6 November 2013

***Modification Request for the University of Sydney Abercrombie Precinct
Redevelopment: Application Number: MP07_0158 MOD 3***

Ground Floor Plan
1:200@A1
11.10.13
4001_DA02-D

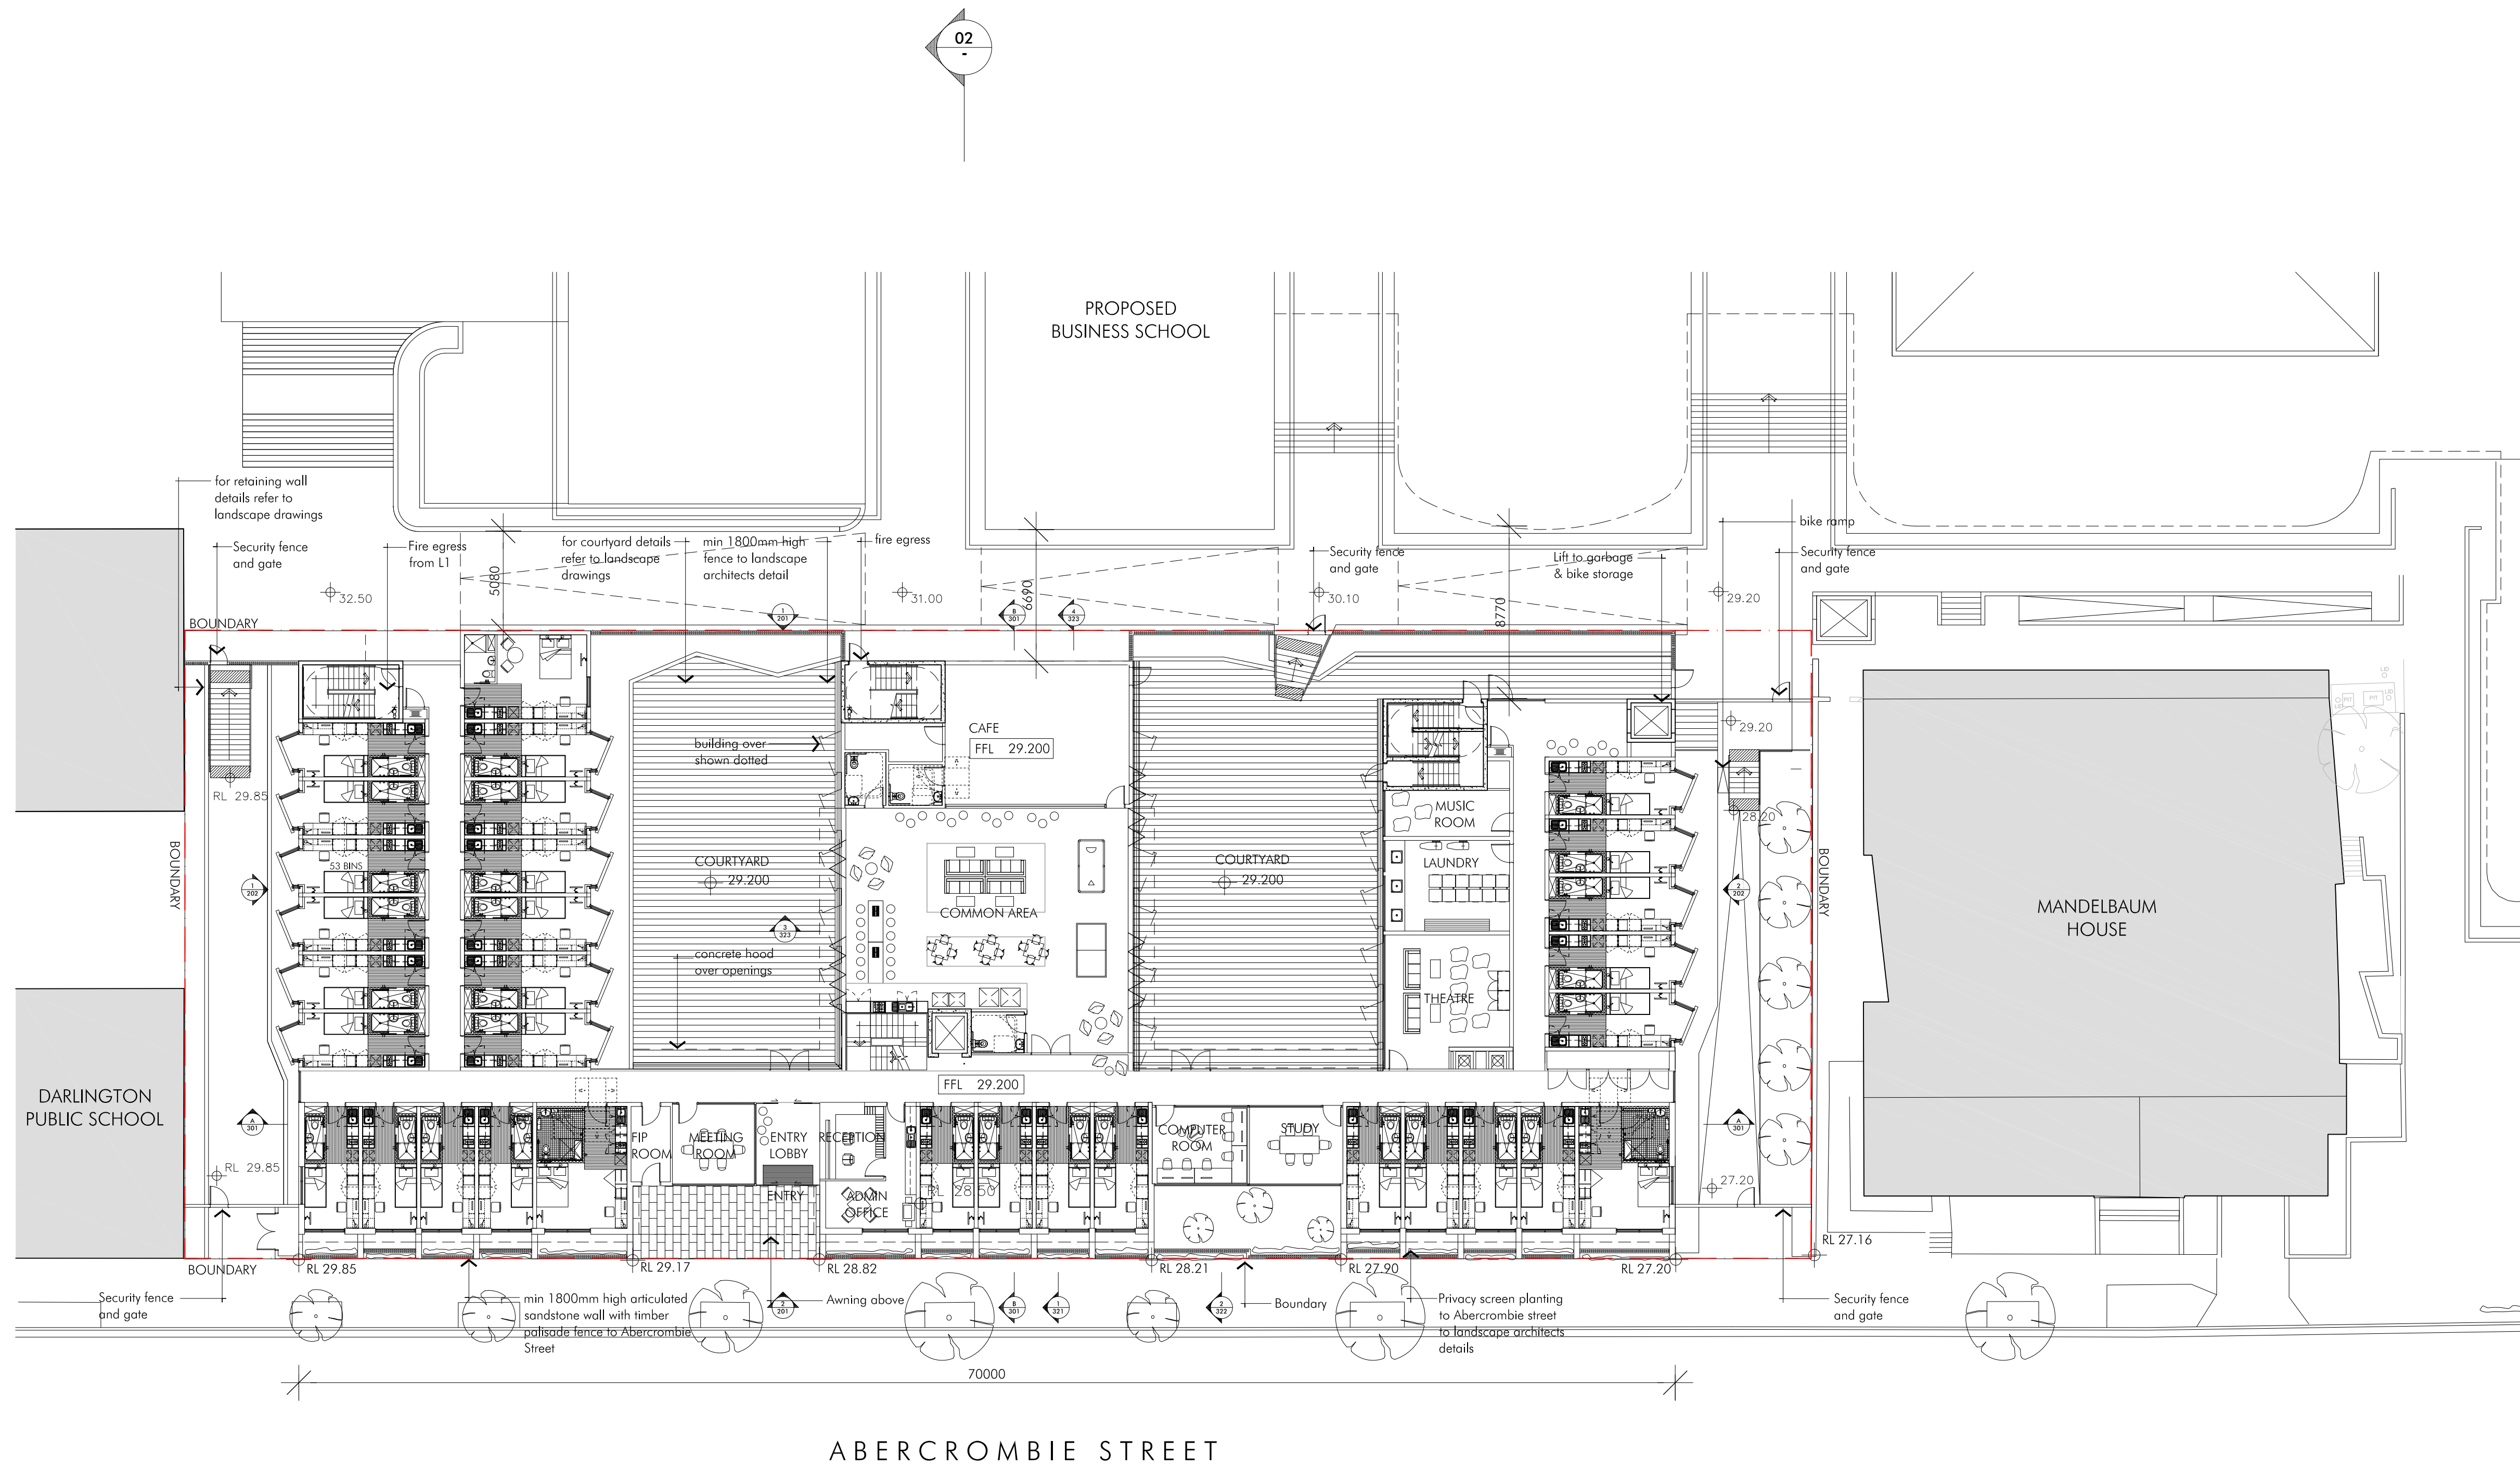
- The front of the Student Accommodation building should be built 2 metres back from the Abercrombie Street boundary. It should be set back from this boundary so that it is in line with Mandelbaum House as it was originally planned and presented to the community. The footprint of the buildings currently on the site, The Shepherd Centre and Boundary Lane Children's Centre, were built approximately 2 metres back from the Abercrombie Street boundary and align with Mandelbaum house. Therefore, the front footprint of the proposed Student Accommodation building should be the same as those buildings occupying the site at present and not be built up to the Abercrombie street boundary.

- The facade of the proposed Student Accommodation building does not reflect the heritage appearance of the Victorian terraces on Abercrombie Street as Mandelbaum House does. Therefore, it should be set back to allow for extensive vegetation and trees to be planted in front of the building on Abercrombie Street to help preserve the heritage streetscape and improve both the aesthetics and the environment of the street.
